2 September 2020

Your Ref: SSD-8636-Mod-2
Our Ref: R/2018/7/E
File No: 2020/384579

New Request for Advice – University of Sydney – Engineering & Technology Precinct – SSD 8636 Modification 2

Sections 03
Southern Courtyard Details

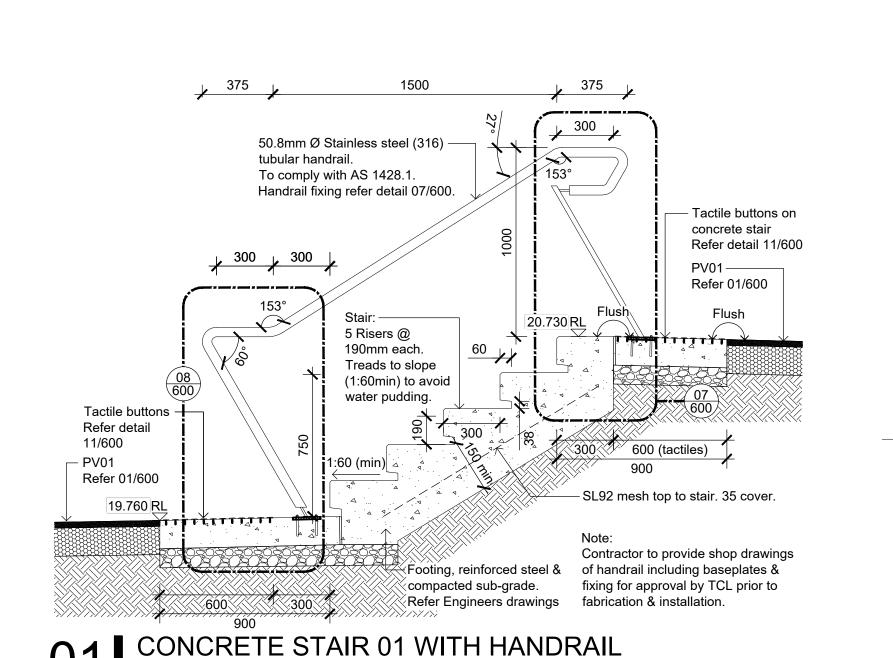
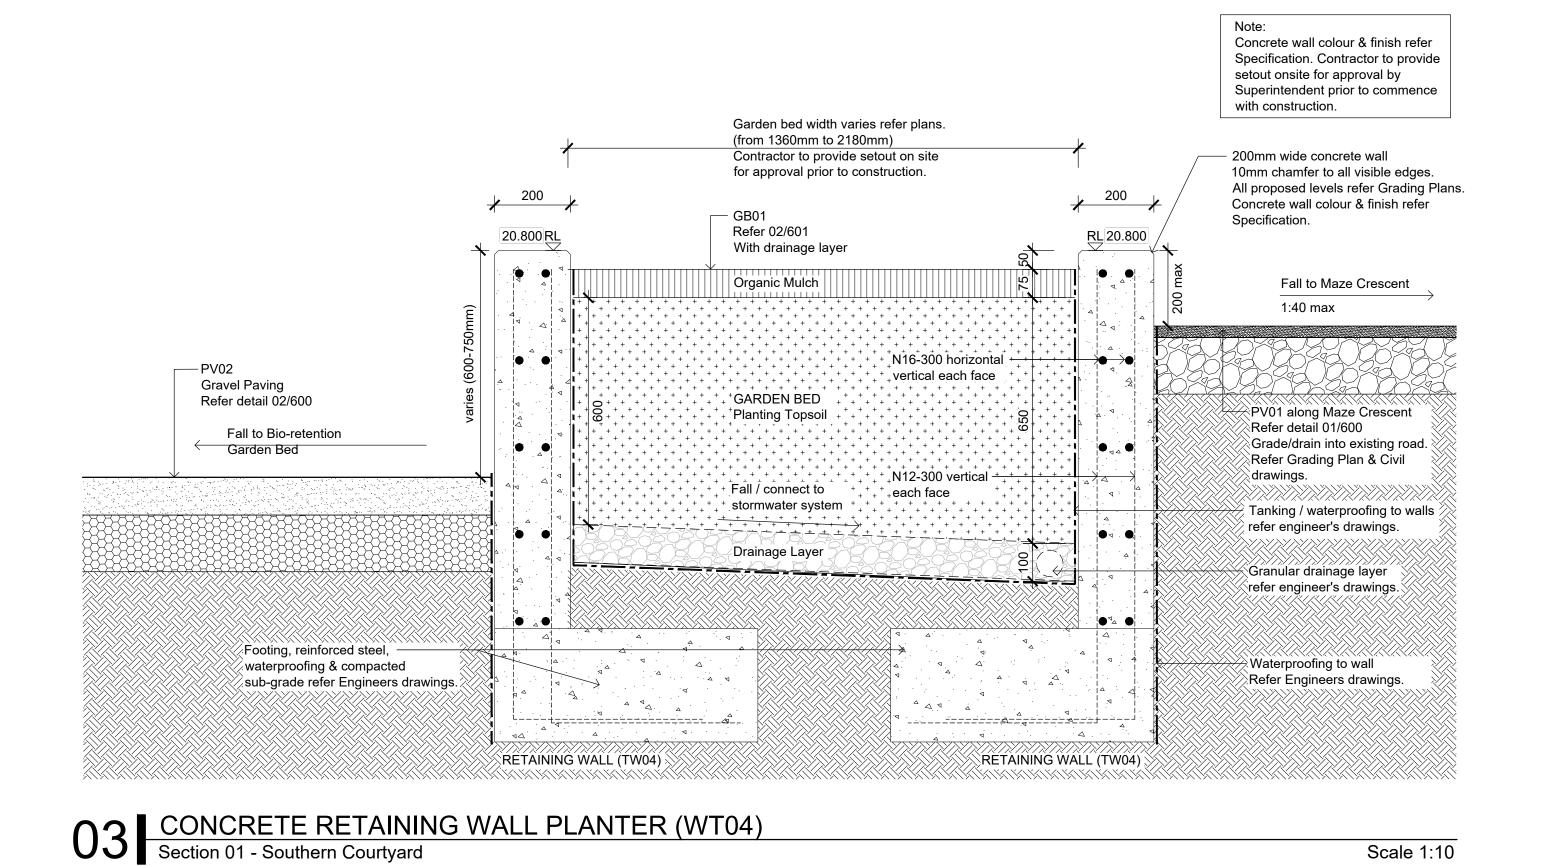
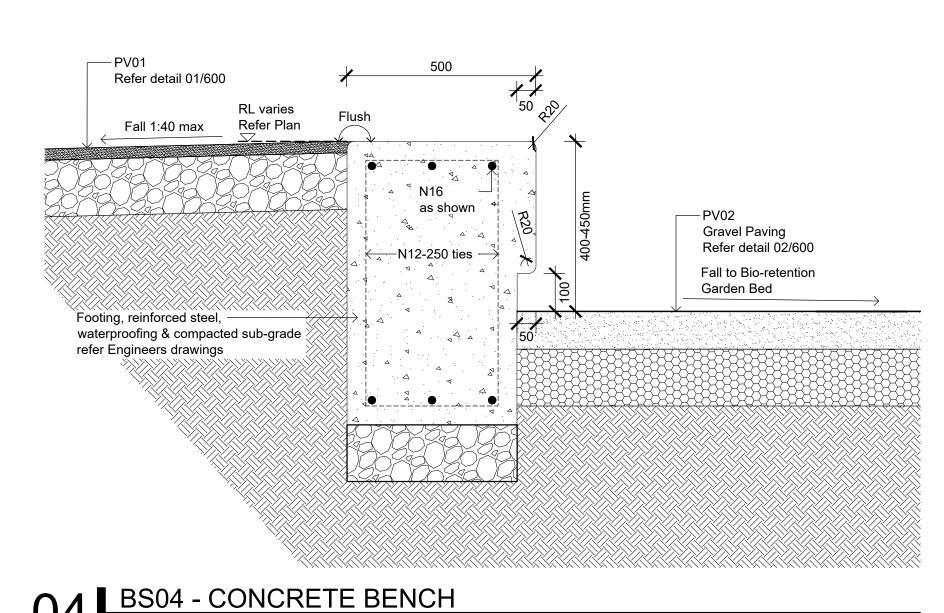
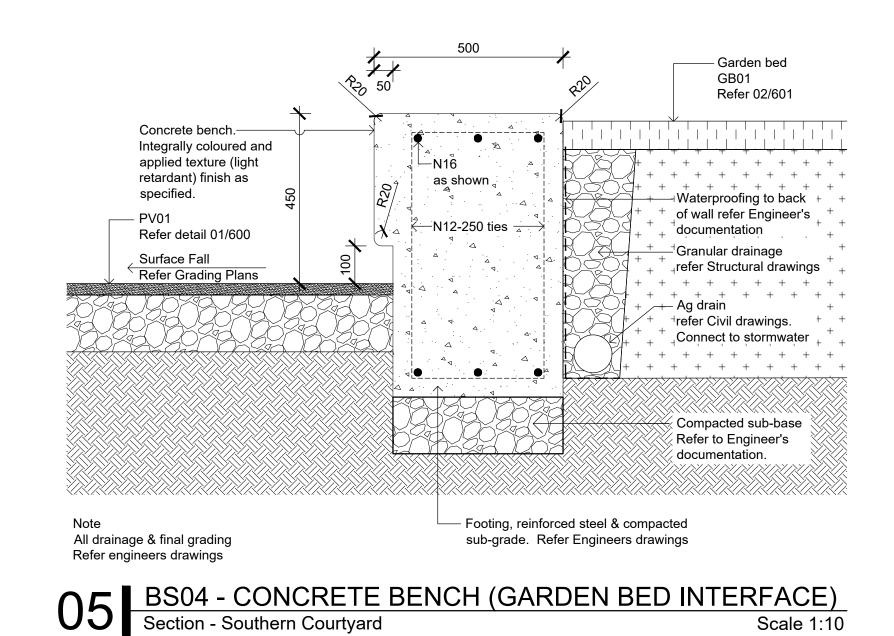
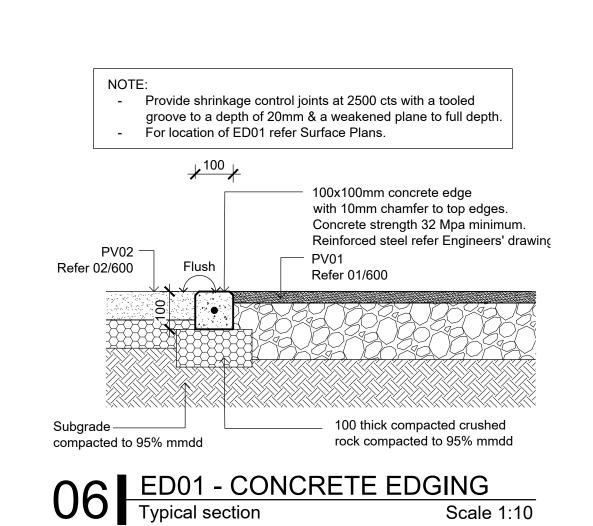
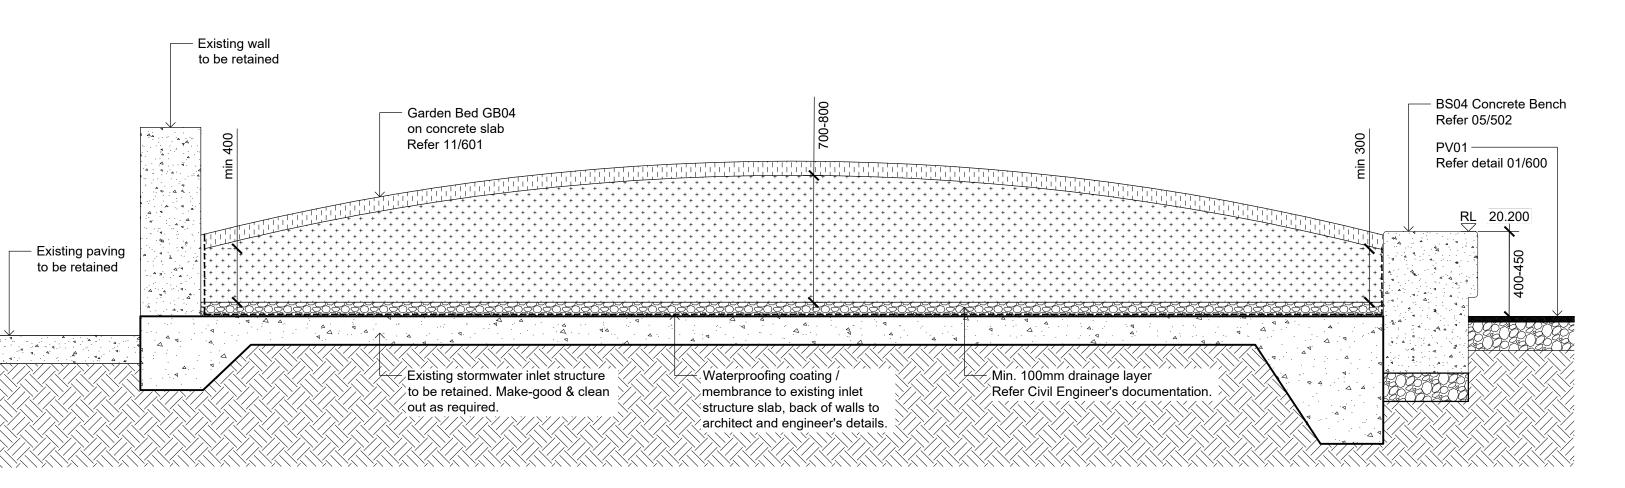
The South Plaza and bioretention /detention basin design varies from the SSDA approved design. This results in a major change to the design layout, symmetry of the outdoor spaces that related to an overriding indigenous strategy for the site, reduces new trees planting from 10 to 6, and reduced surface materials and features.

The proposed raised planting walls are low and rely on 1:3 mounds to achieve 600-700mm soil depth. The planters on slab do not provide adequate soil depth to support healthy tree growth and do not comply with the Sydney Landscape Code.

Southern Courtyard

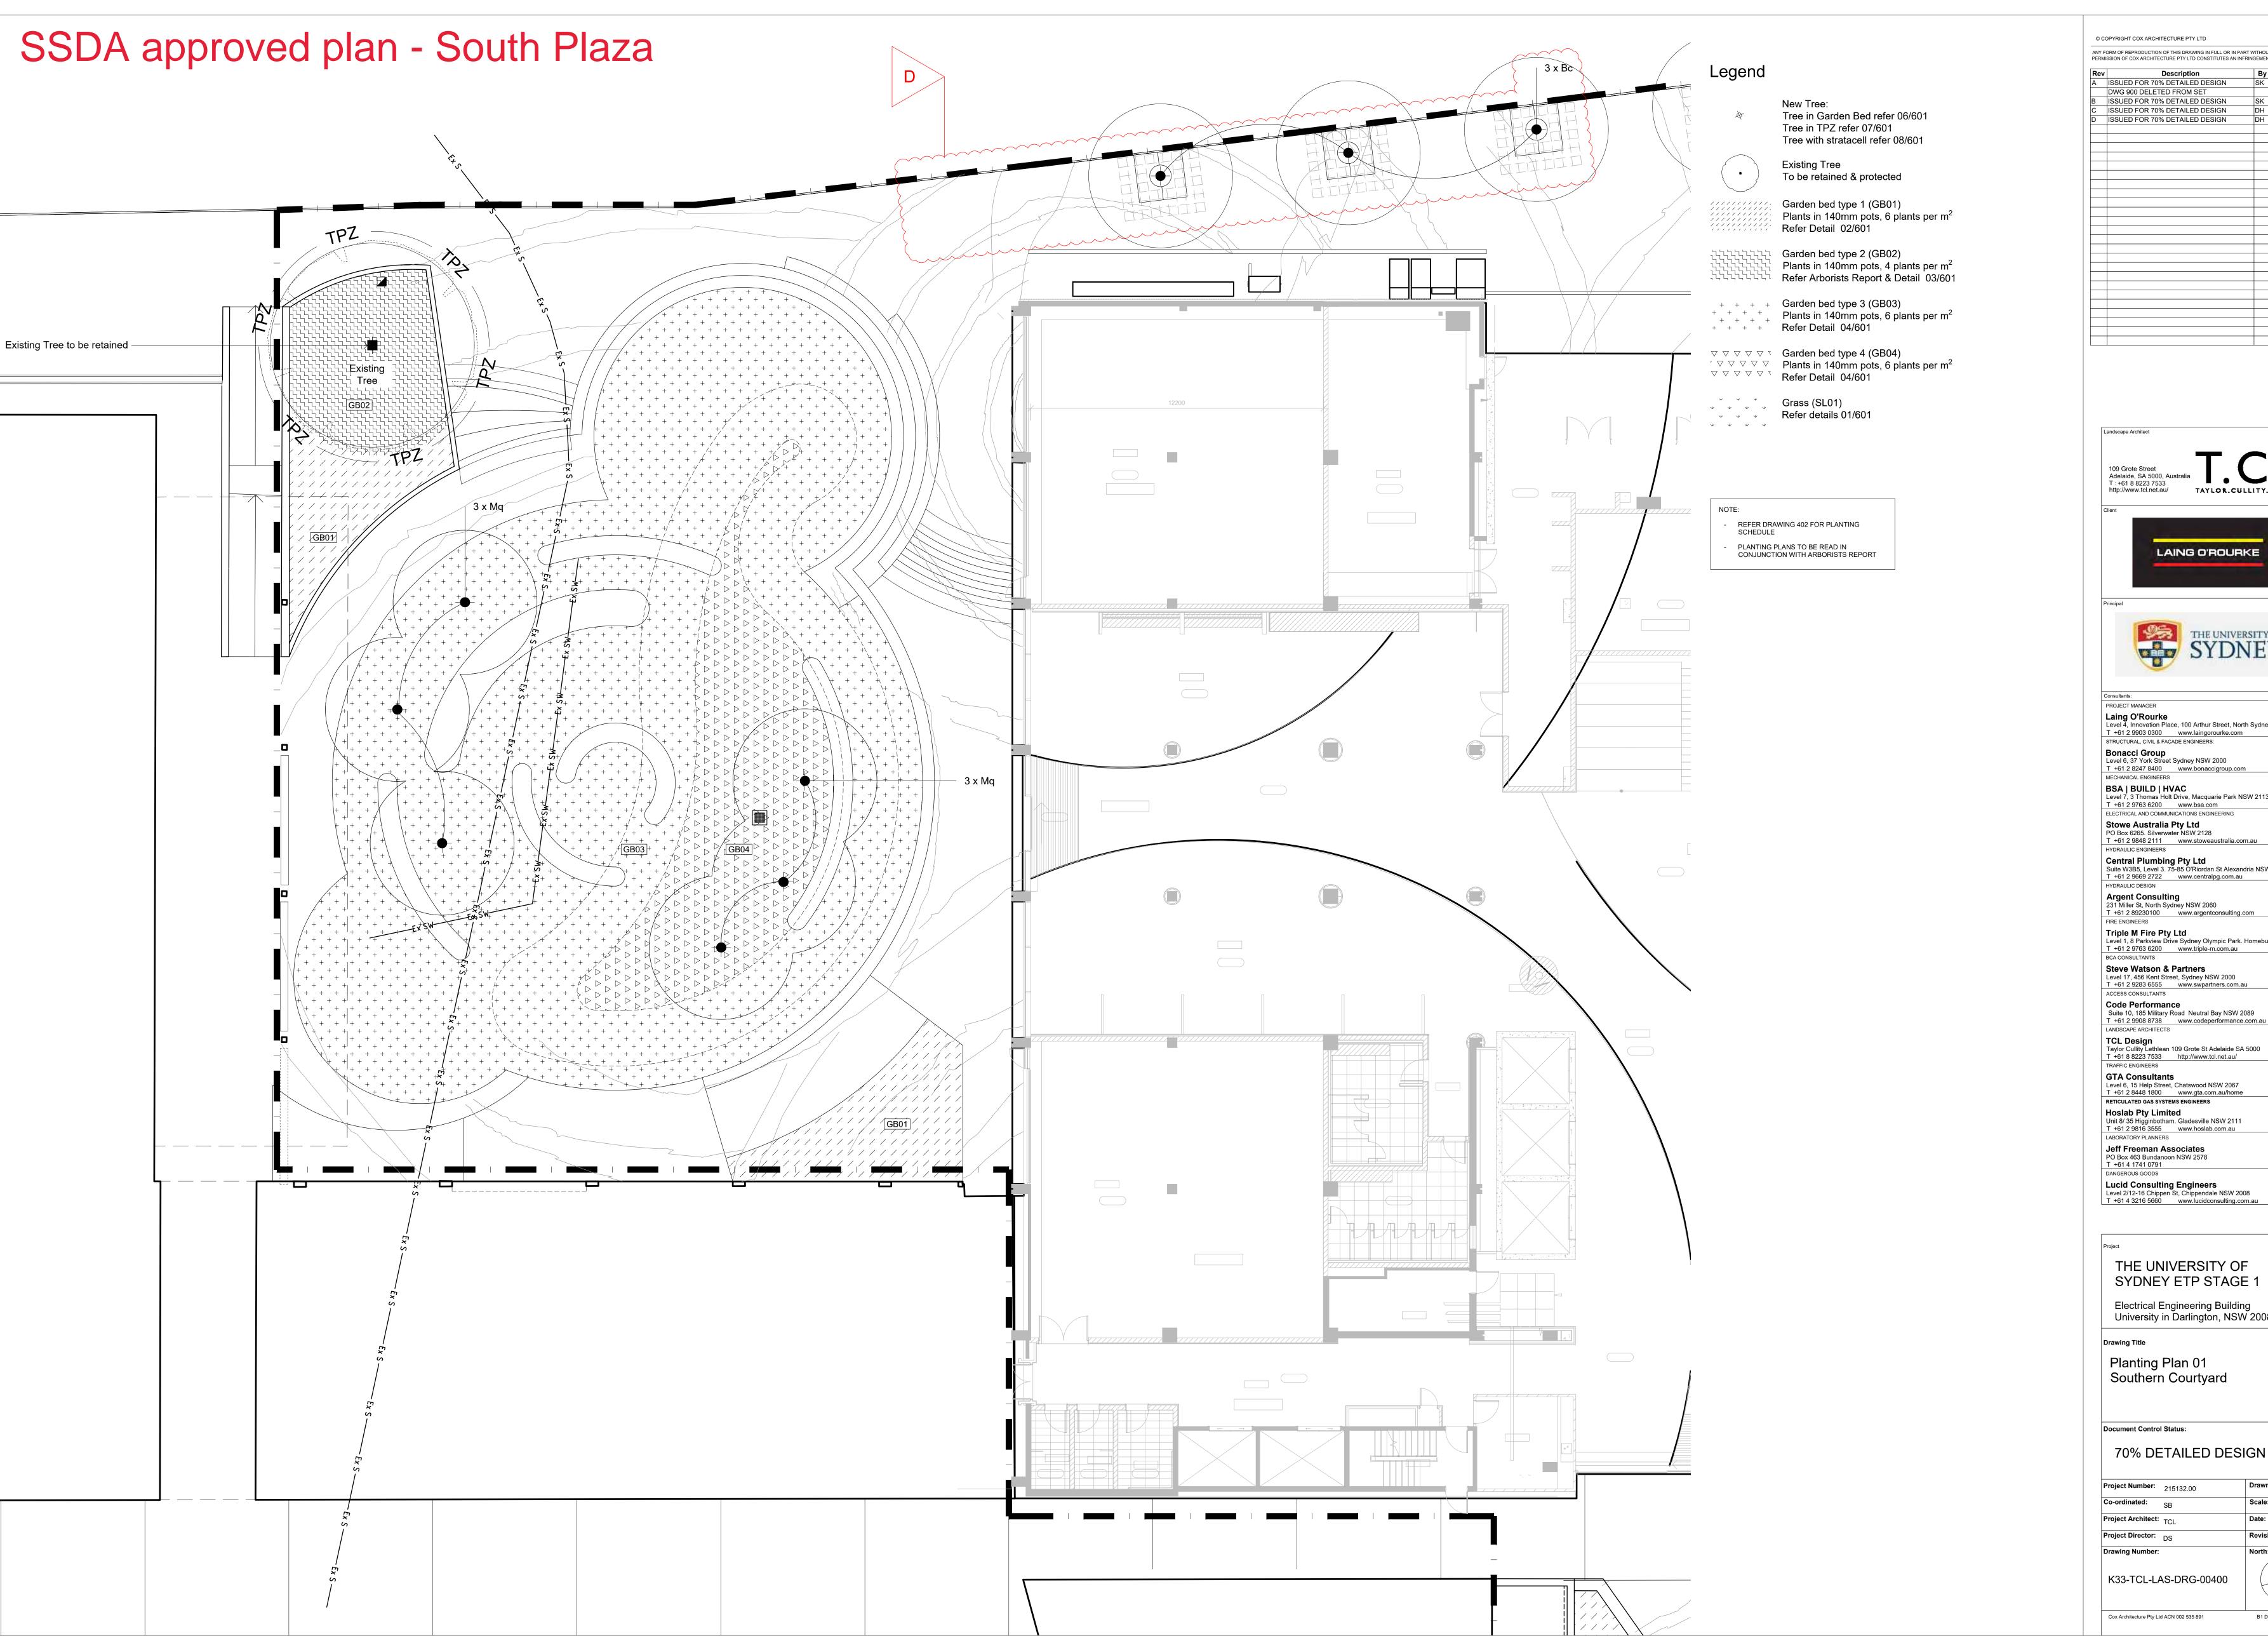
The amended Landscape Plan proposes the substitution of six *Melaleuca quinquenervia* (Paperbark) in the South plaza detention basin with six *Jacaranda mimisifolia* (Jacaranda). Jacaranda trees are an exotic semi-deciduous tree species, native to South America. Paperbark trees are evergreen trees endemic to the eastern coast of Australia. Paperbark trees naturally grow in swampy areas and are culturally important to the Aboriginal and Torres Strait Islander peoples.

The approved South Plaza plans proposed planting the Paperbark trees within a garden bed, ideal conditions for healthy tree growth and aiding in mitigation of flood water. The Jacaranda trees as shown on the proposed South Plaza plan will be planted in compact gravel, with restricted root growth by the concrete retaining walls and are situated too close together (future canopy conflicts and suppression of healthy canopies). The proposed design for the South Plaza would be a poor design outcome for supporting healthy canopy trees, contributing to the site 15% canopy coverage in accordance with Sydney DCP 2012 and aiding in the mitigation of flooding.
